M5 Junction 10 Improvements Scheme

Combined Change log for Statement of Reasons,
Book of Reference, Land Plans and Crown Land
Plans

TR010063 - APP 9.22

Volume 9
October 2024

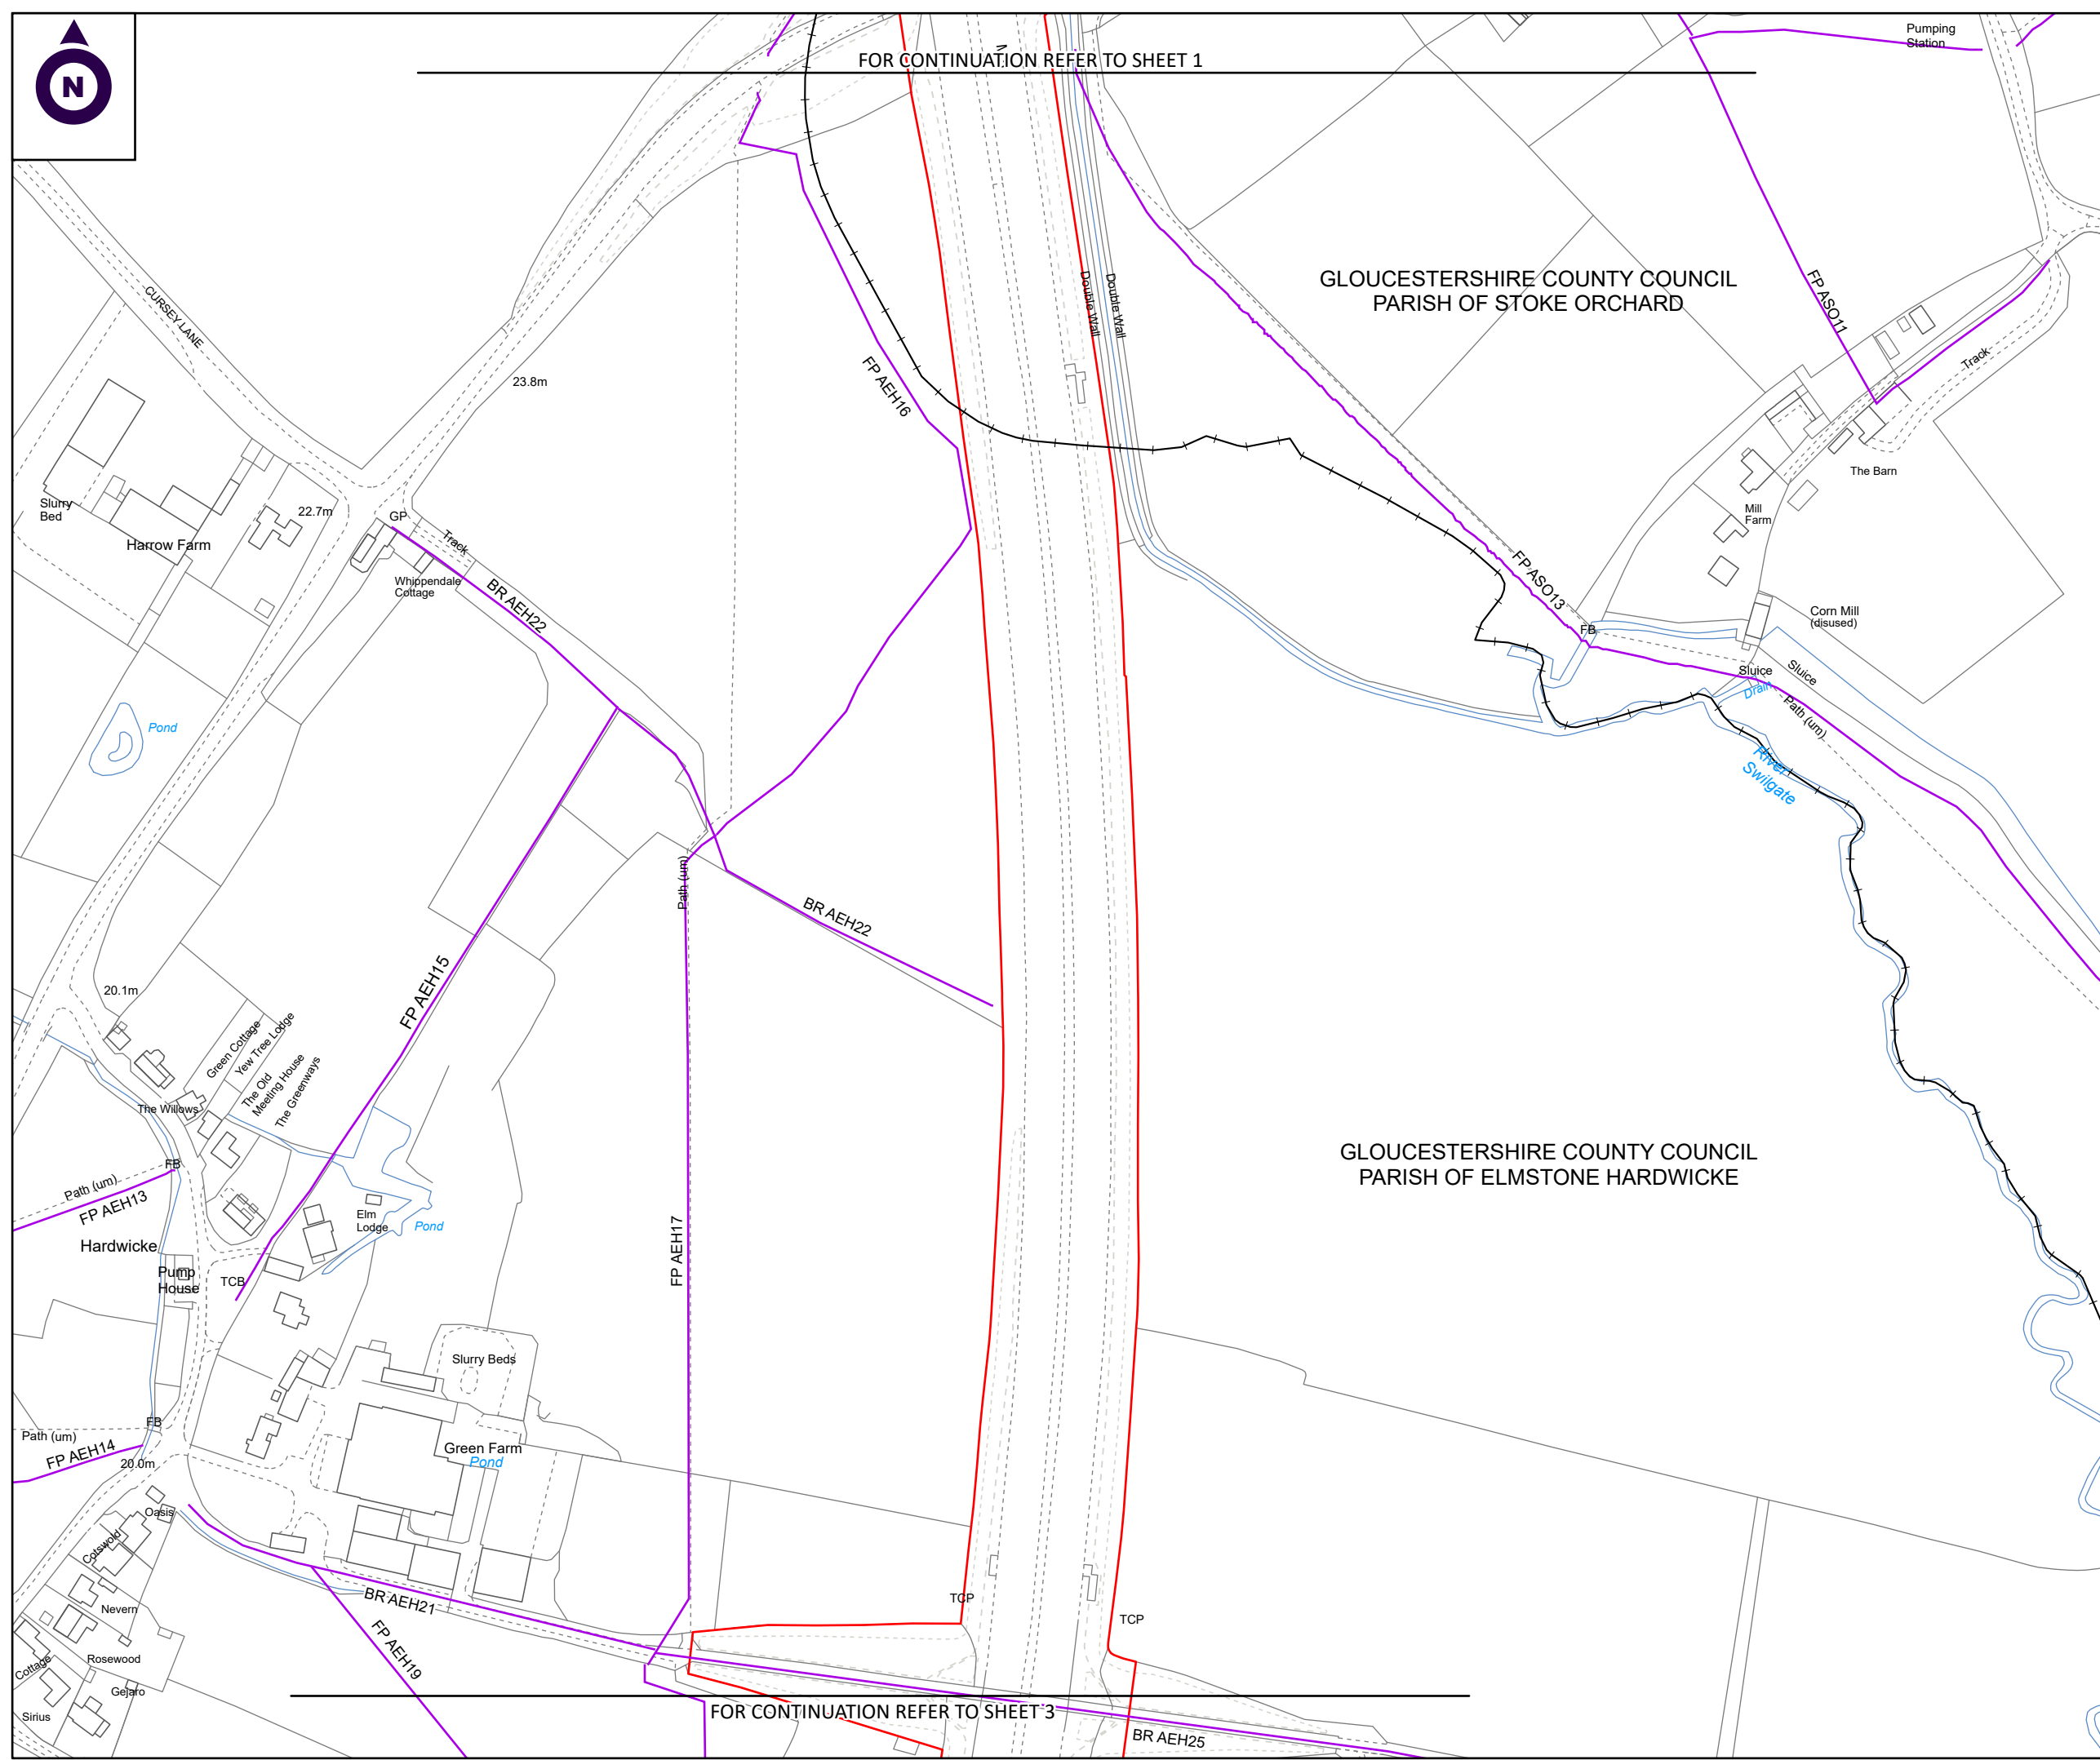
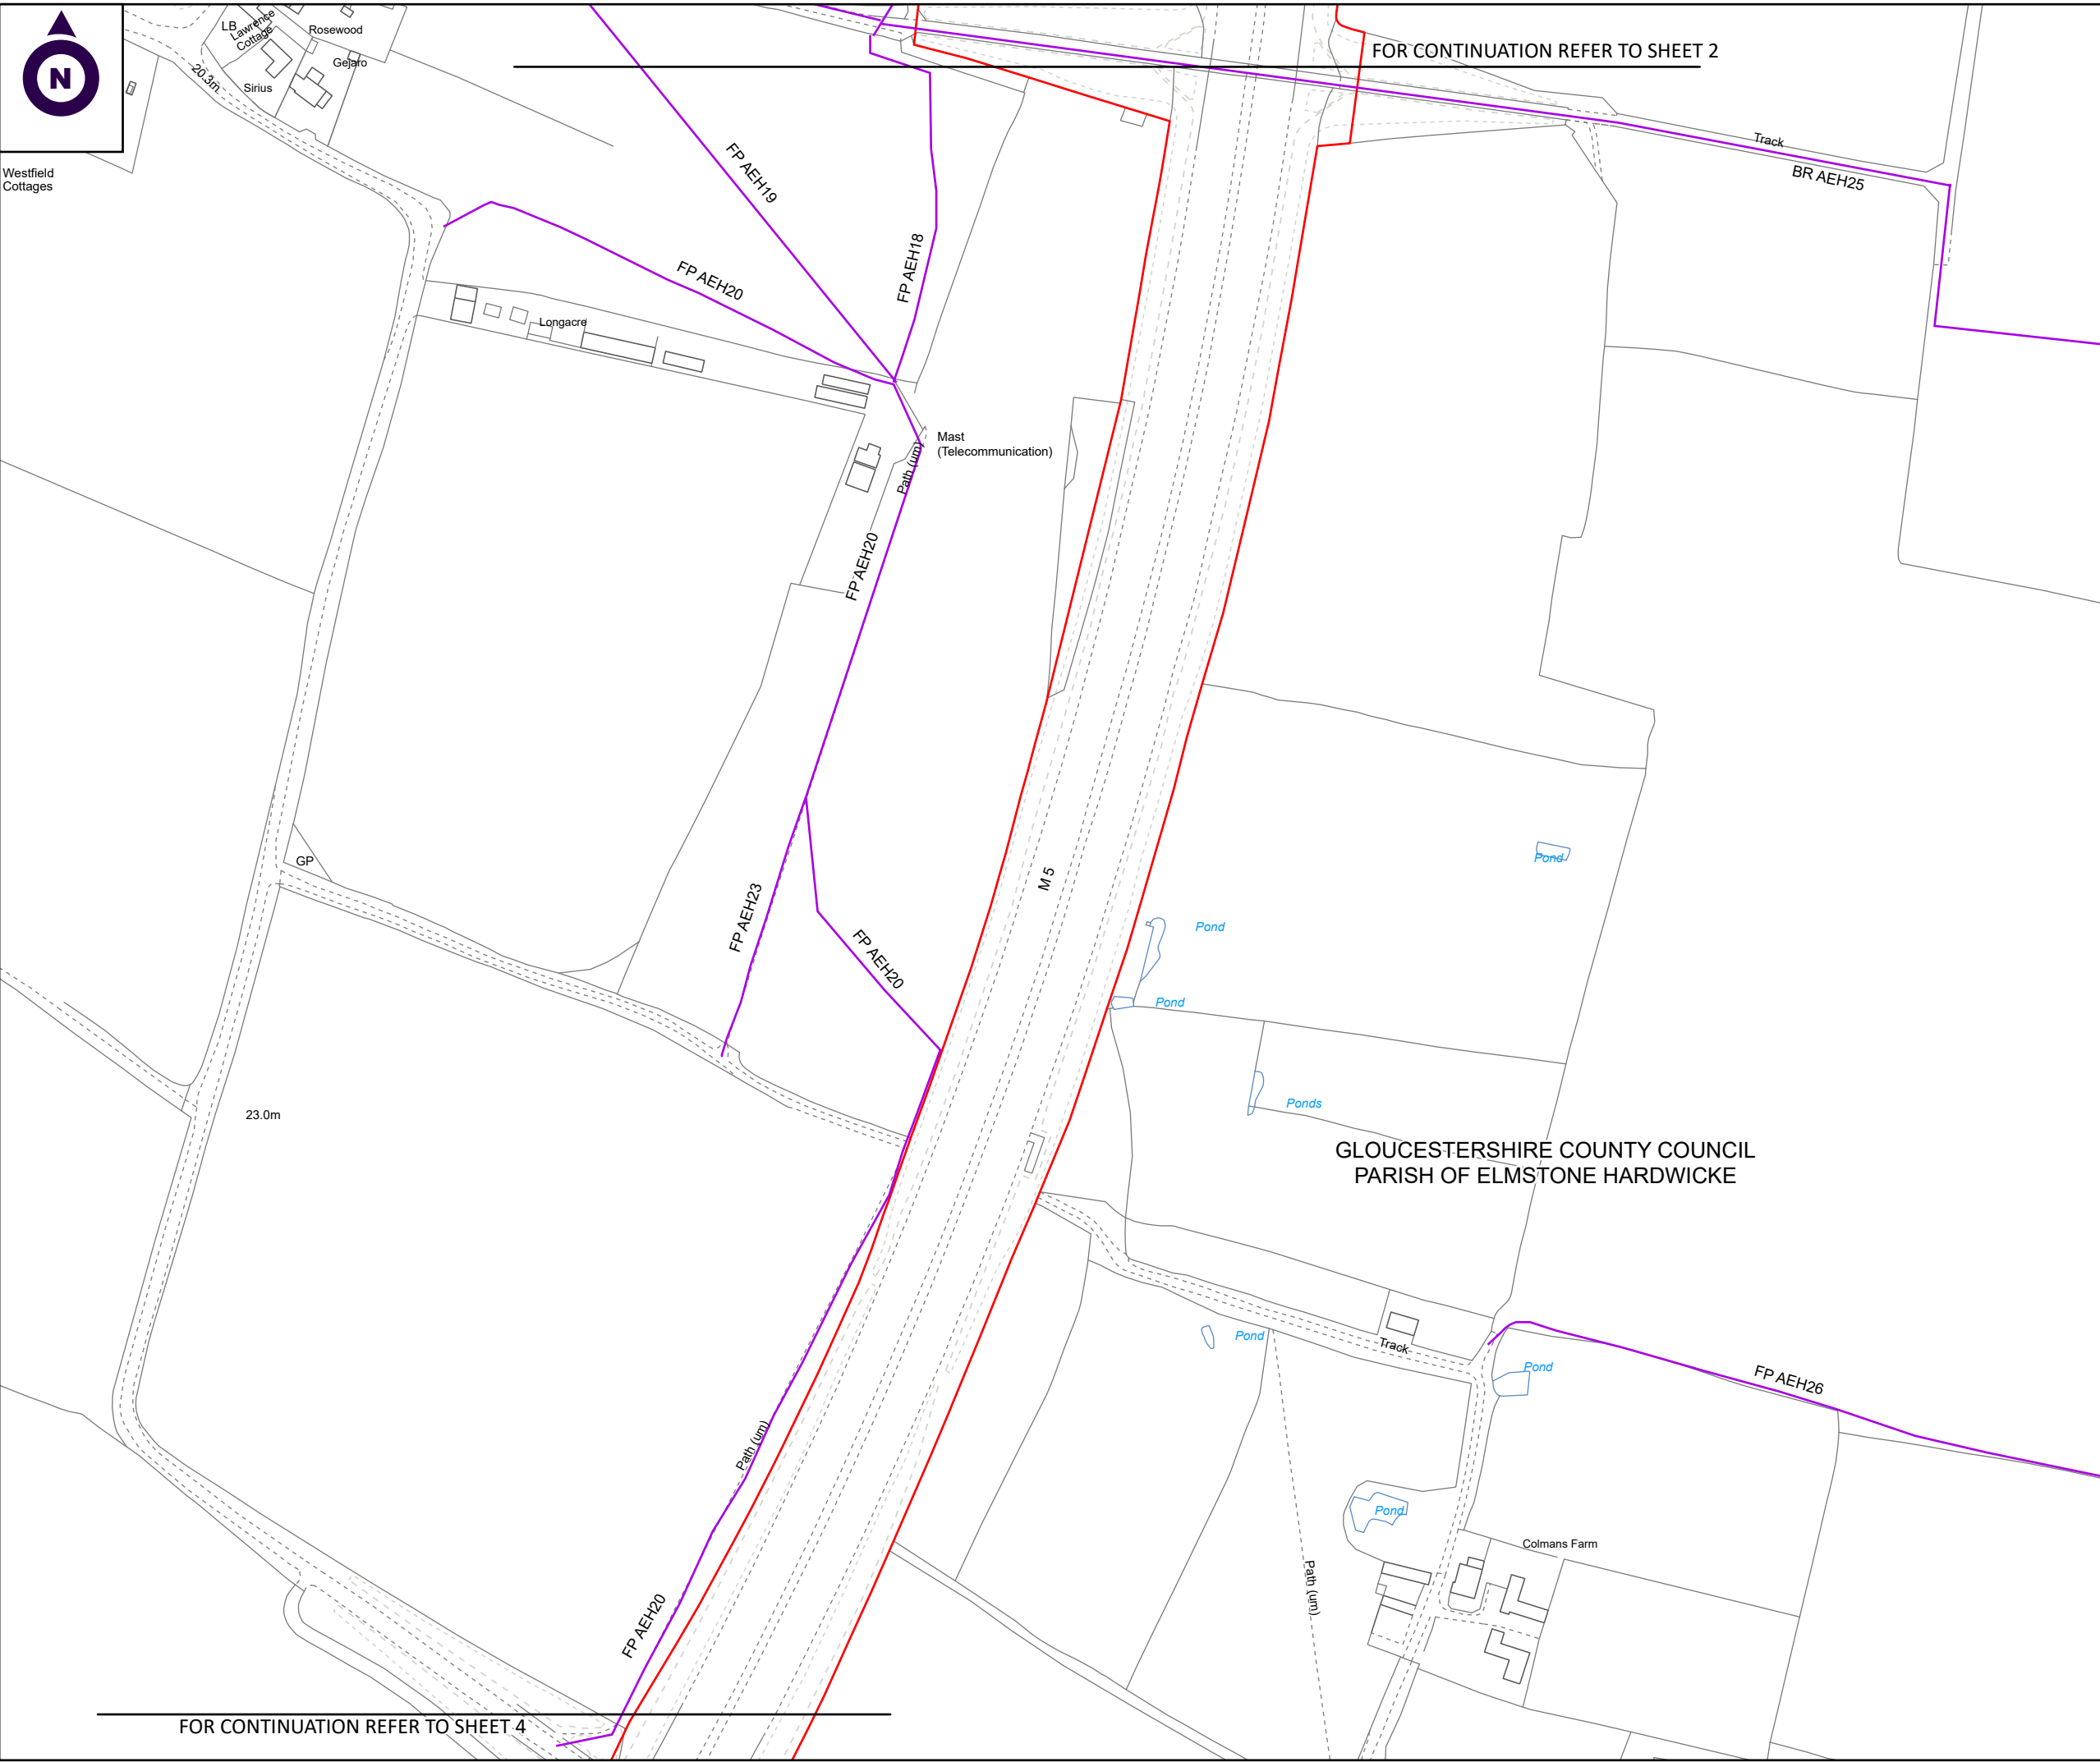
Change No.	Plot No.(s)	Document	Change
1	3/2c	Land Plan Sheet 3	Plot downgraded from rights/temporary (blue) to temporary (green)
2	3/2c	SoR	Plot downgraded from rights/temporary to temporary only with works no 1a 'Required for the construction of motorway signage and associated cabling and ducting works'
3	3/2c	BoR	Plot downgraded from right/temporary to temporary only
4	4/1c	Land Plan Sheet 4	Plot downgraded from acquisition (pink) to rights/temporary (blue)
5	4/1c	SoR	Plot downgraded from permanent acquisition to rights/temporary only with works no 1a 'New right for the construction of motorway signage and associated cabling and ducting works', 1c 'New right for the construction of a new southbound exit slip from the M5 to the A4019', 1e 'New right for the construction of a new northbound entry slip from the A4019 to the M5' and 1n 'New right for the construction of an environmental barrier adjacent to Barn Farm north of Junction 10 and west of the M5'
